Our Ref: BR/49/18/HH
Your Ref:

Town & Country Planning Act 1990 (as amended)
Town & country Planning (Development Management Procedure) (England) Order 2015
Application for Planning Permission for Works or Extension to a Dwelling

Development Two storey side & single storey rear extensions.
Location 11 Elmwood Avenue Bognor Regis

LOCATION PLAN
 SITE OUTLINED IN RED

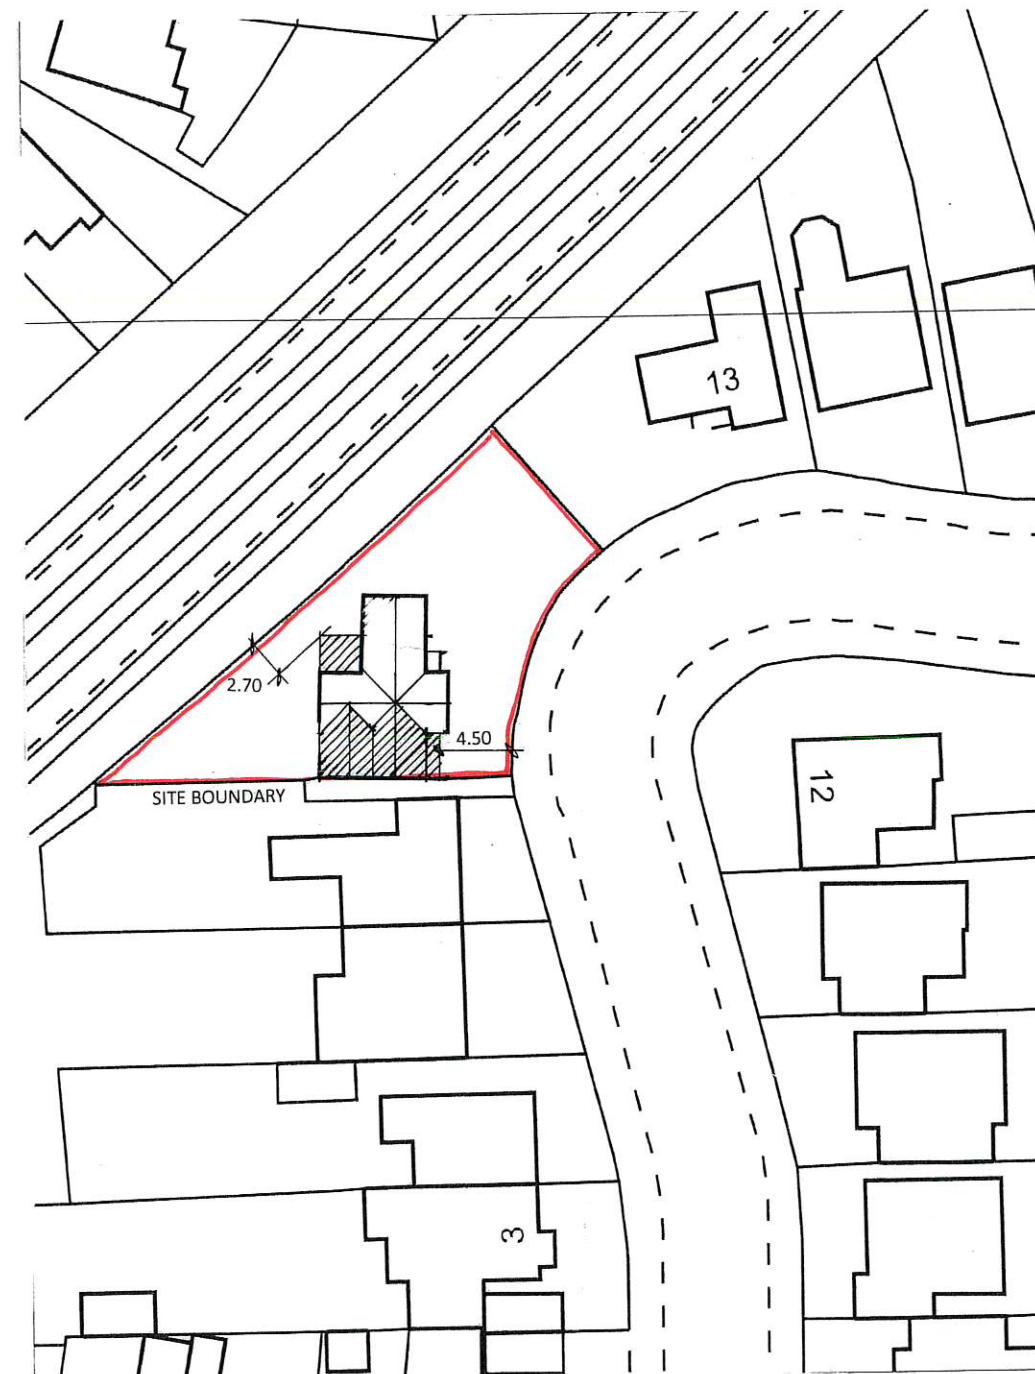
Location Plan Amend

Please submit 1 electronic or 3 paper copies of a location plan at a scale of 1:1250 or 1:2500 for rural areas. Further details of what must be included on the plan can be found in the National Validation Requirements. Please red edge the site.

BLOCK PLAN
 SITE OUTLINED IN RED AND PROPOSED
 EXTENSION SHOWN SHADED

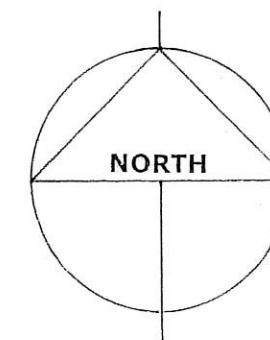
Block Plan Amend

Please submit 1 electronic or 3 paper copies of a block/site plan at a scale of 1:500 or 1:200. Further details of what must be included on the plan can be found in the National Validation Requirements. Please provide measurements from the proposals to the site boundaries.

CLIENT
MR/MRS A STENNETT
PROJECT
PROPOSED ALTERATIONS AND EXTENSION
11 ELMWOOD AVENUE
BOGNOR REGIS PO22 8DE
DRAWING TITLE
EXISTING GROUND FLOOR PLAN
SCALE
1/50 at A3
REFERENCE
11713.02

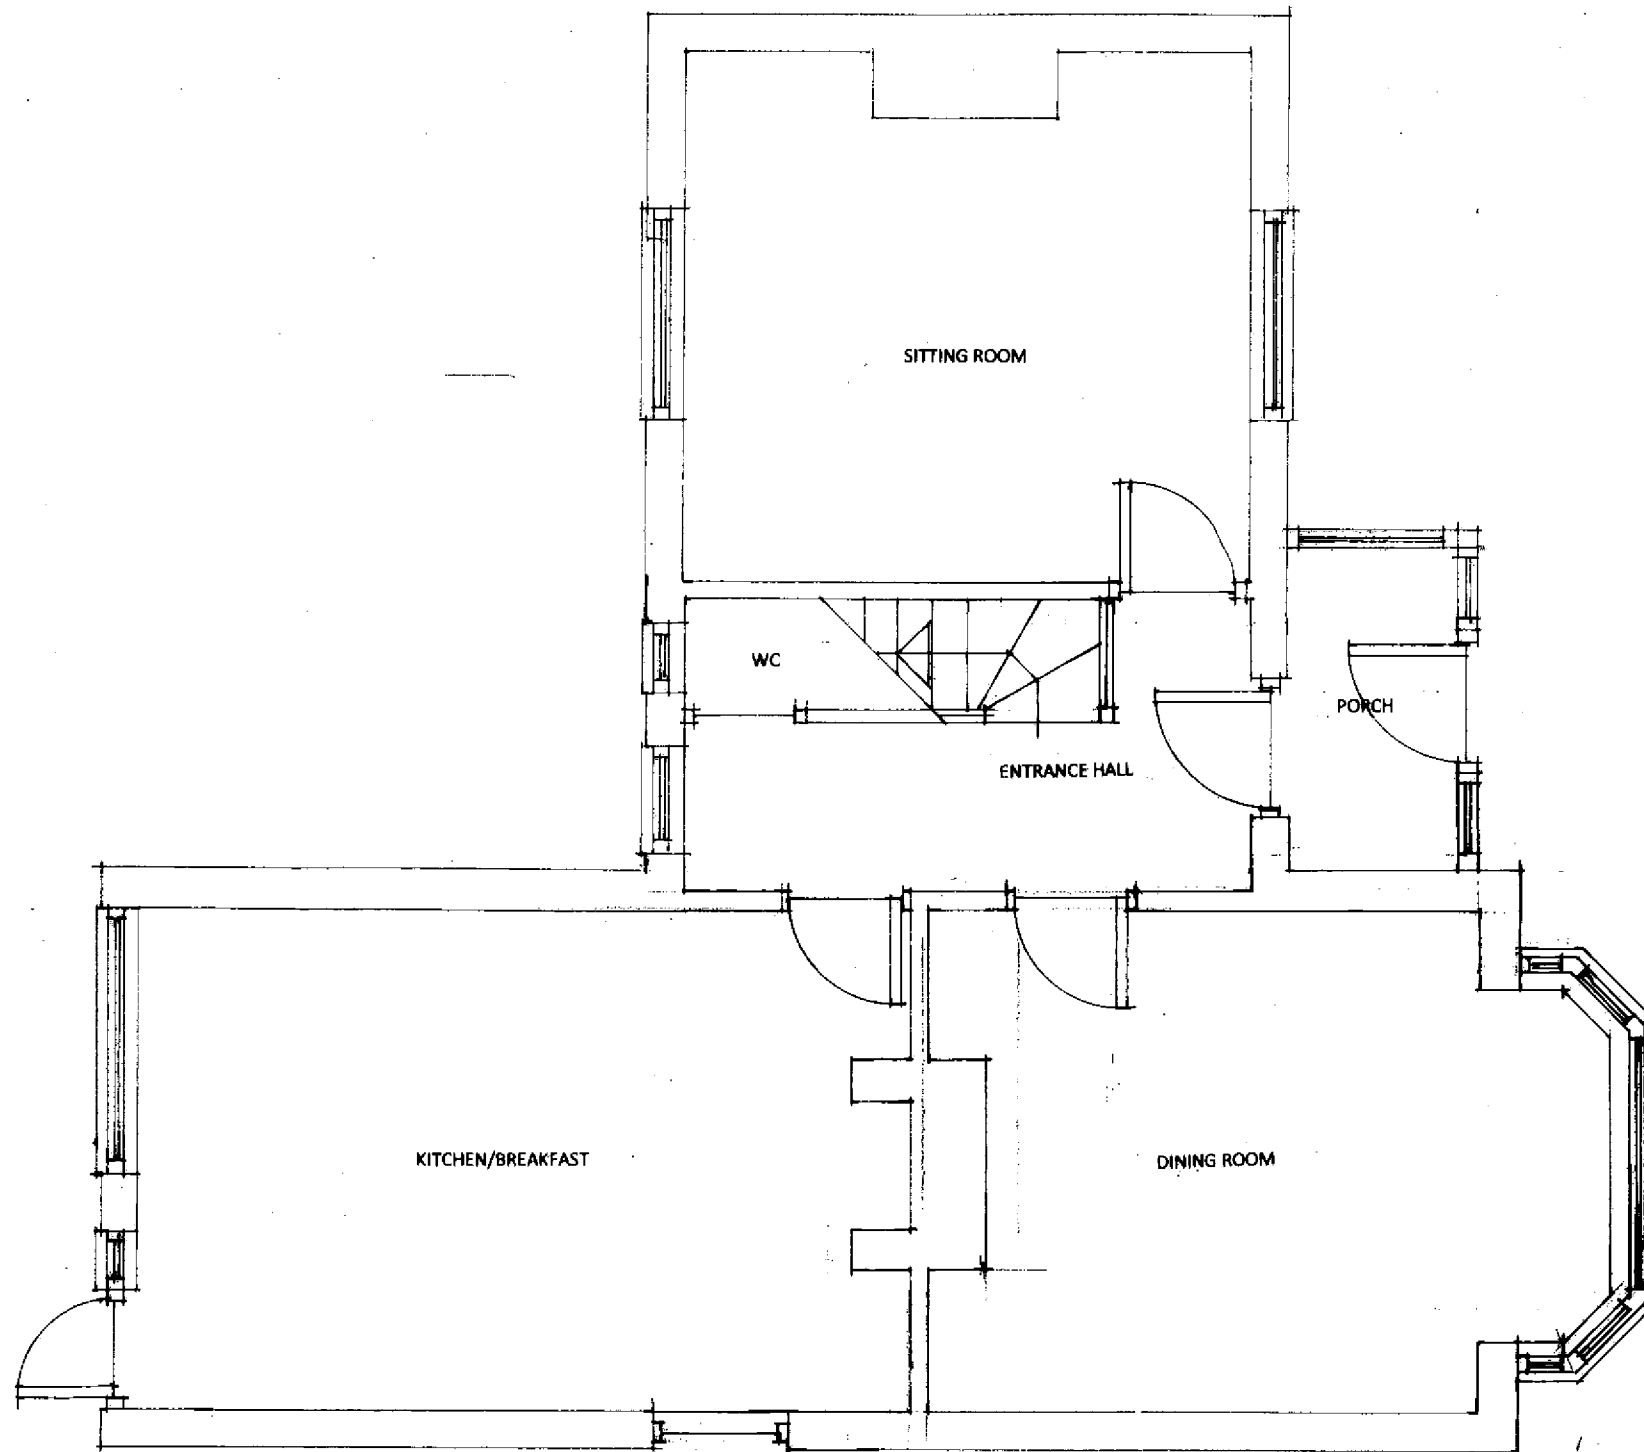
The existing south elevation and ground floor plan do not accord. Please amend accordingly.

CLIENT
MR/MRS A STENNETT
PROJECT
PROPOSED ALTERATIONS AND EXTENSION 11 ELMWOOD AVENUE BOGNOR REGIS PO22 8DE
DRAWING TITLE
EXISTING FIRST FLOOR PLAN
SCALE
1/50 at A3
REFERENCE
11713.03

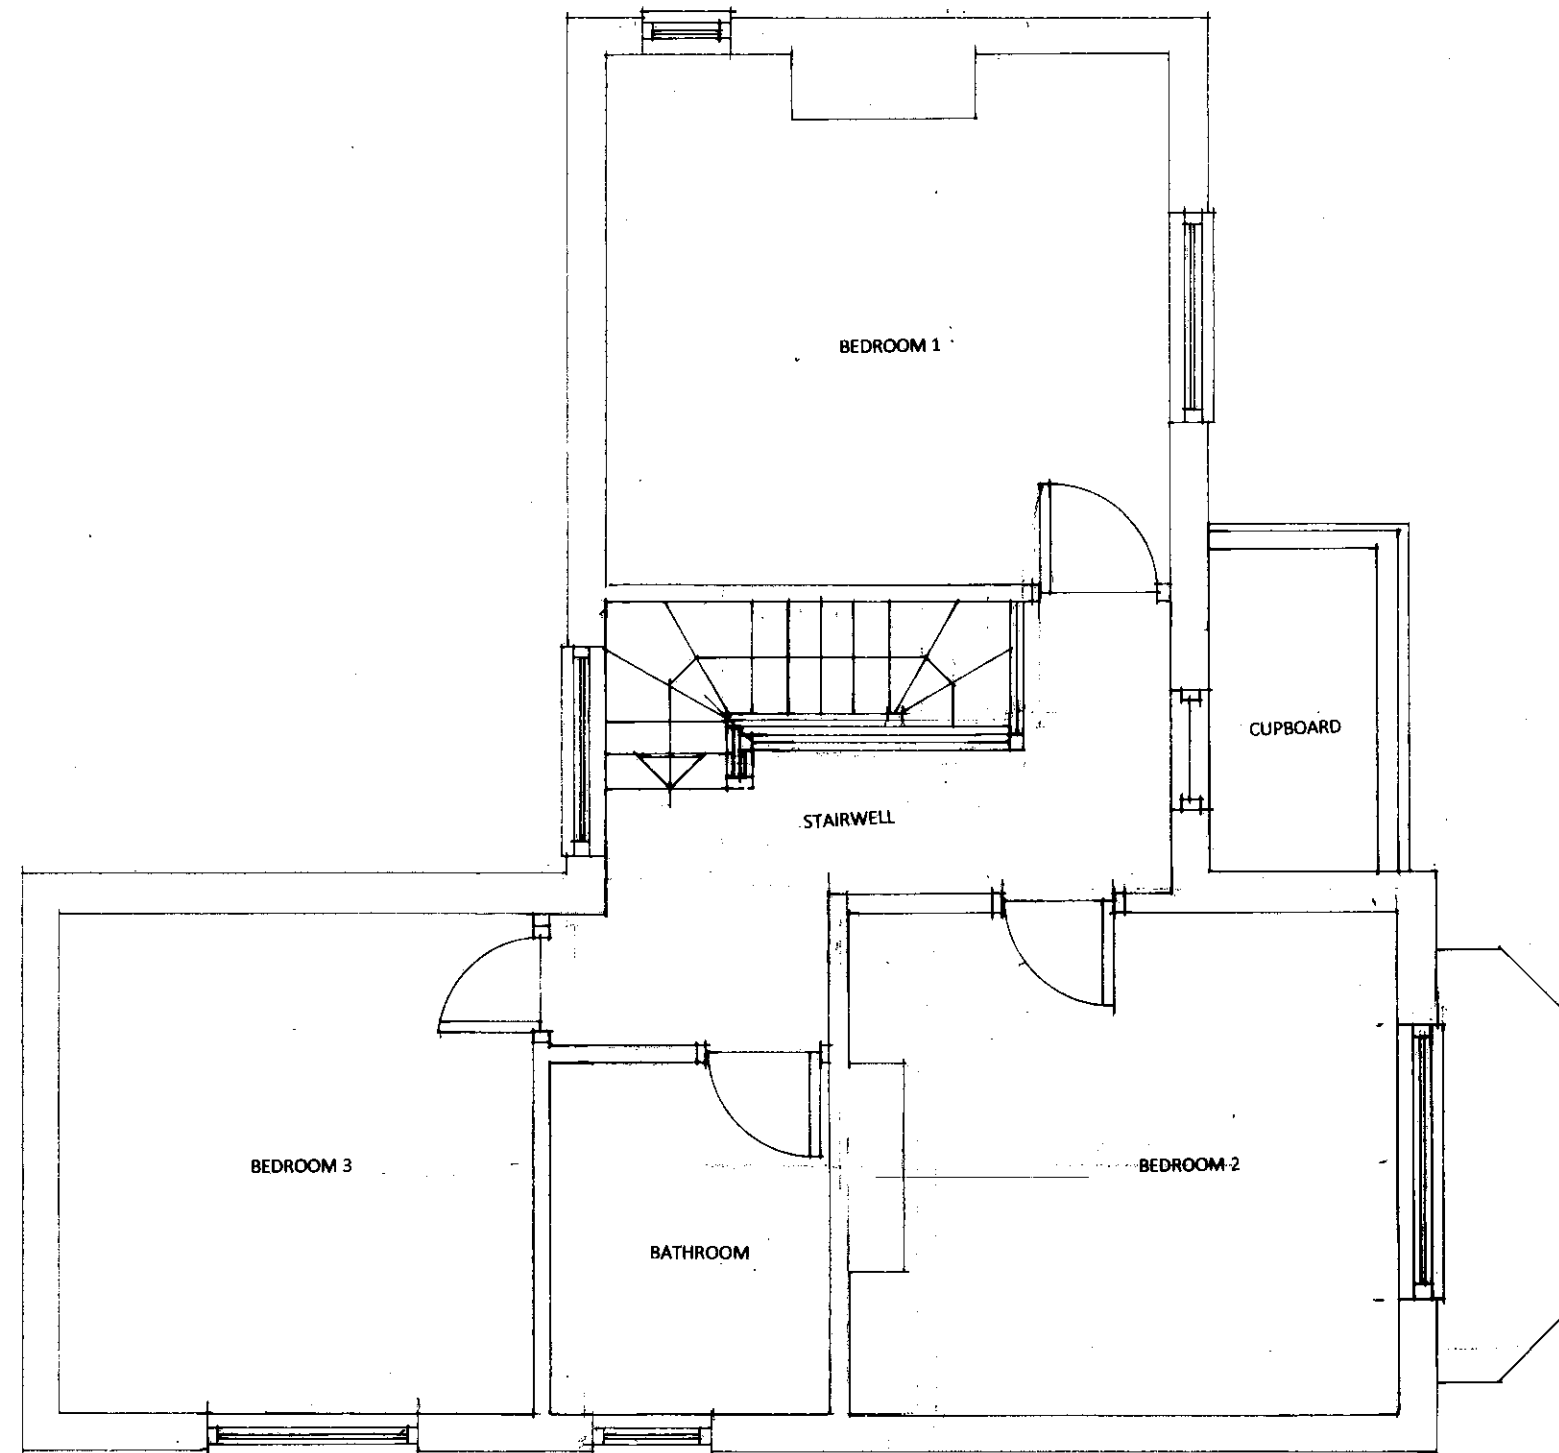
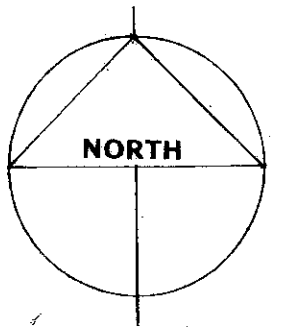
The existing west elevation and first floor plan do not accord. Please amend accordingly.
